From: Hill, Grace <Grace.Hill@e-lindsey.gov.uk>
Sent: 08 January 2026 11:35
To: Patman, Oscar <Oscar.Patman@sholland.gov.uk>
Cc: De-Ruyck, Chris (ELDC) <Chris.De-Ruyck@e-lindsey.gov.uk>
Subject: H16-1089-25 ecology comments

H16-1089-25 - BRIDGE FARM HOLBEACH ROAD SPALDING PE12 6JP

Proposed conversion of existing barns to office use and the development of a padel club on adjacent land

PROPOSED SITE PLAN INC. FENCING ELEVATIONS

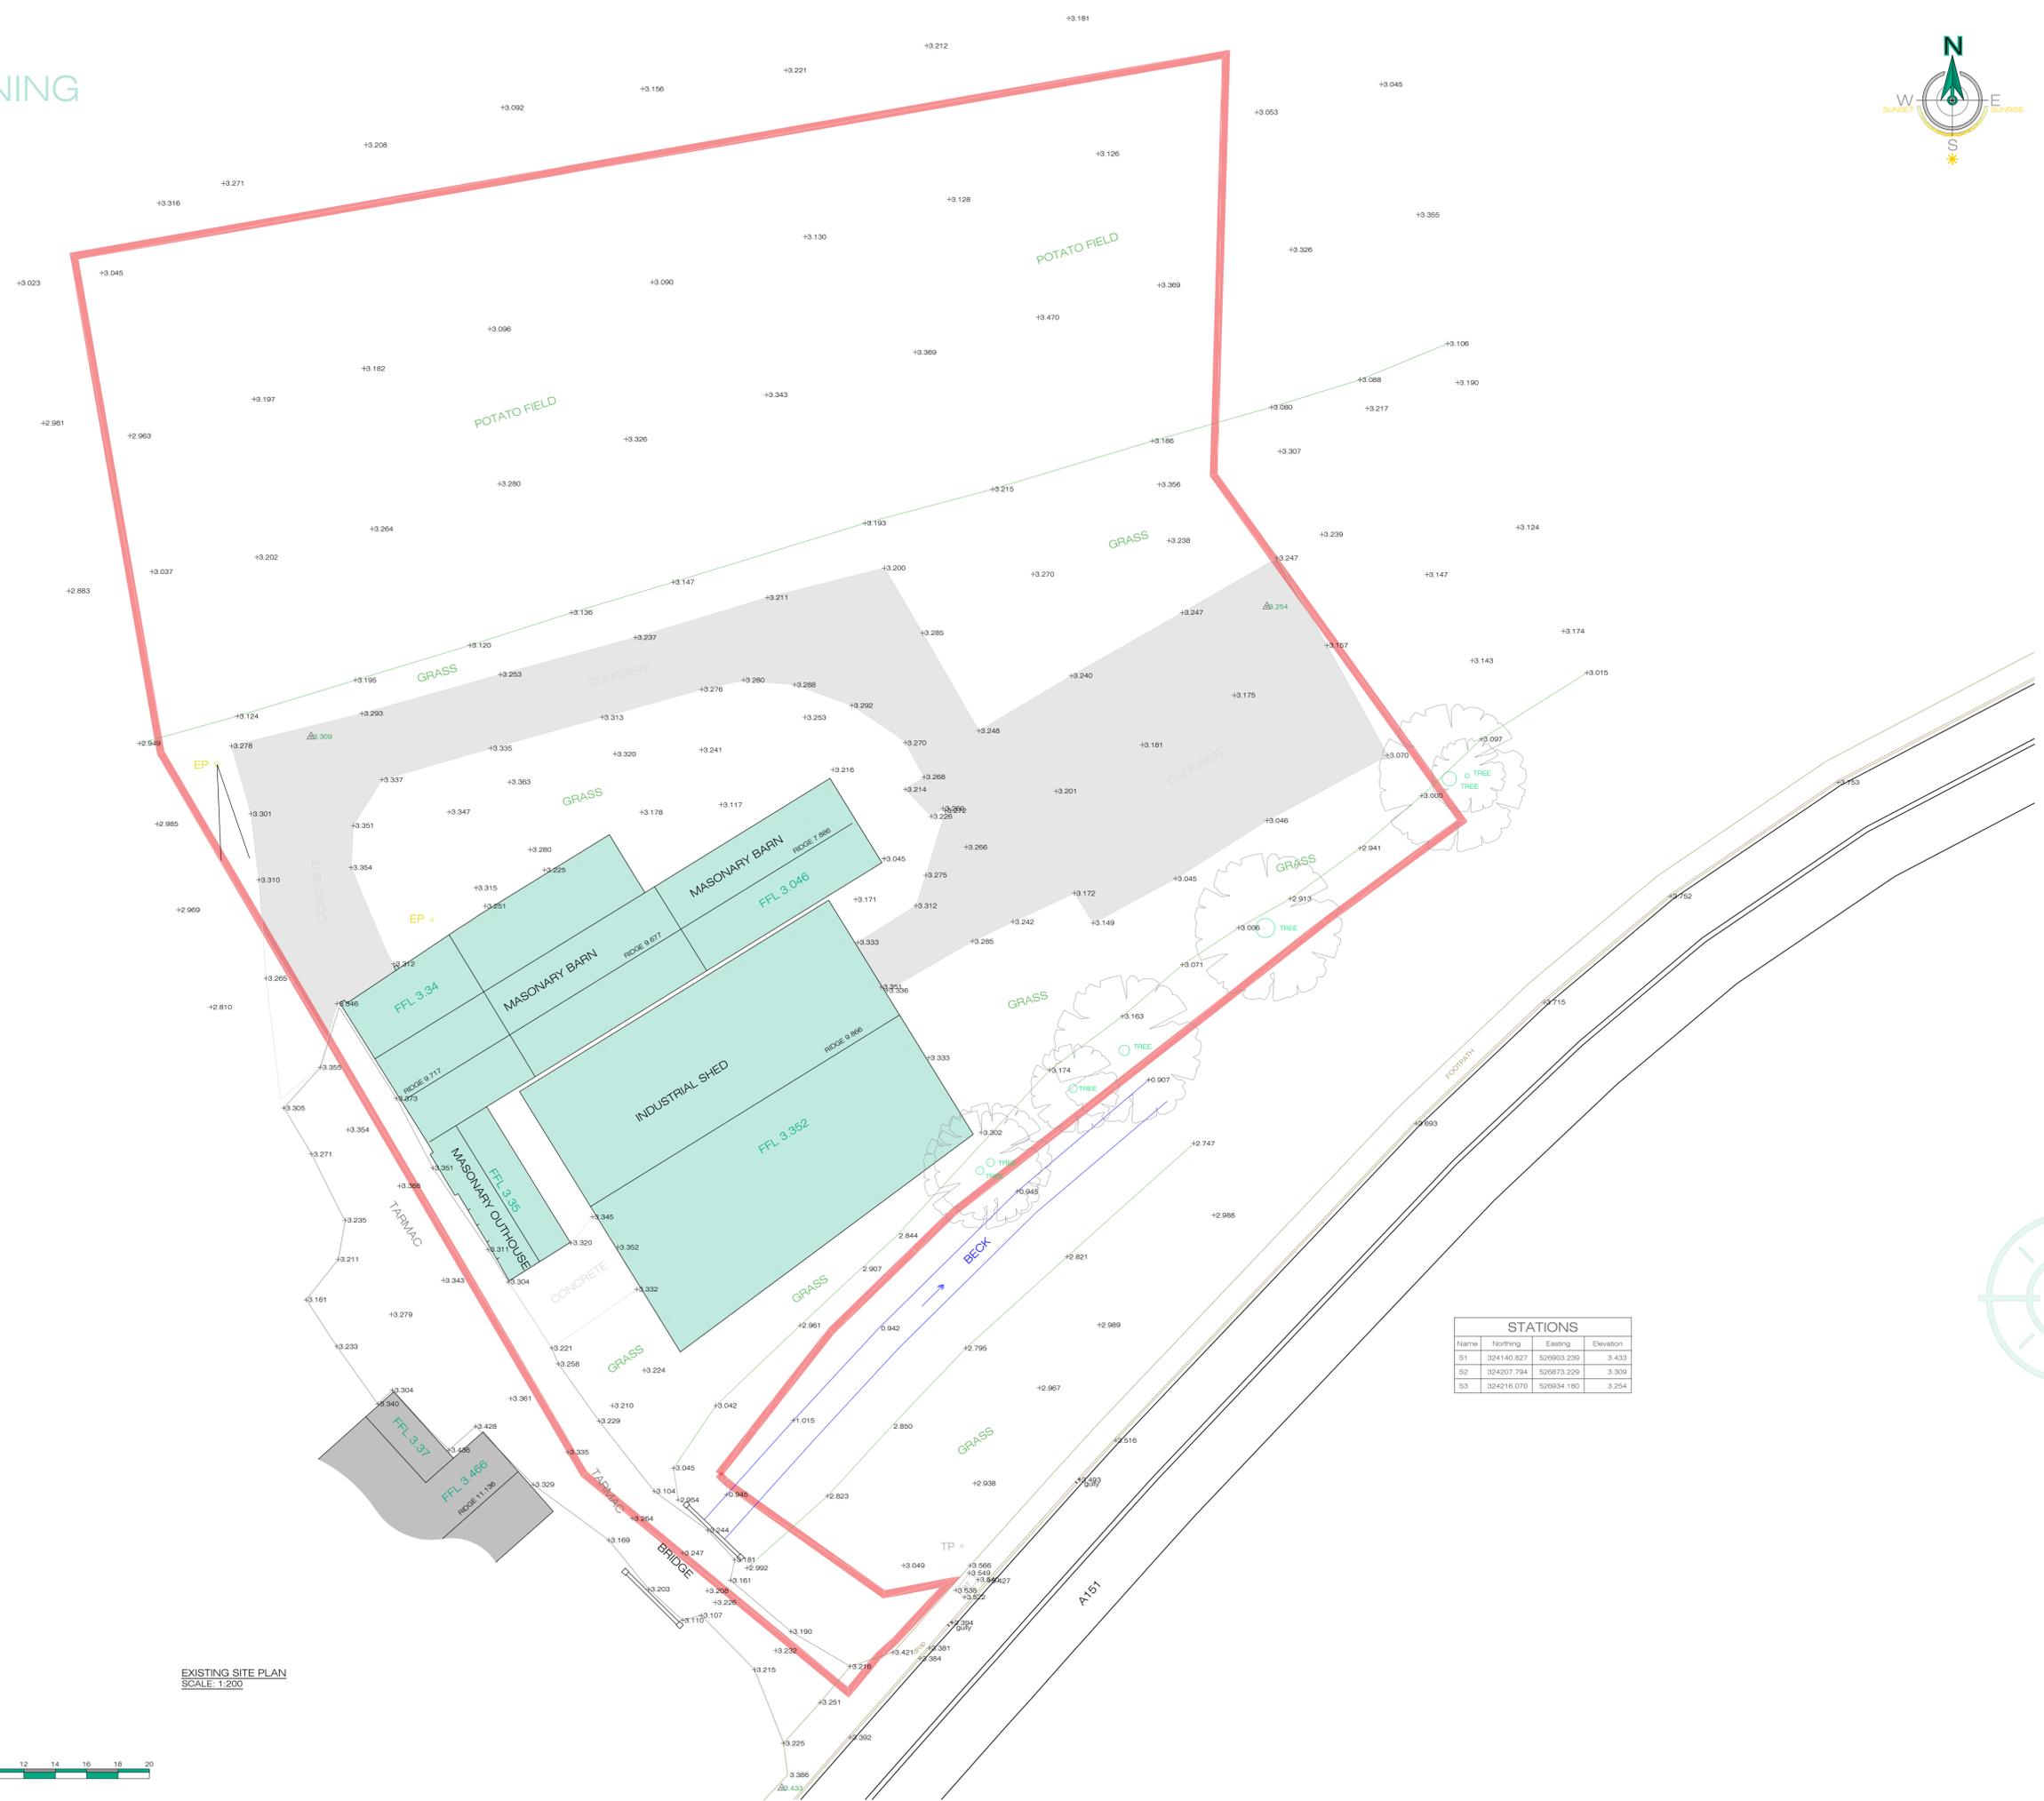
- We aren't confident that good condition modified grassland can be achieved on this site due to the relative complexity to create with the increased external pressures. We believe that having poor target condition grassland around the padel court and moderate condition grassland covering the rest of the onsite grassland creation would be a more suitable habitat target condition.

- We are also concerned that the trees in the centre of the site are proposed to be planted too closely together. We would recommend they alter their proposed tree planting in this area to have ½ the number of trees (would mean there are 37 proposed trees for the site overall).
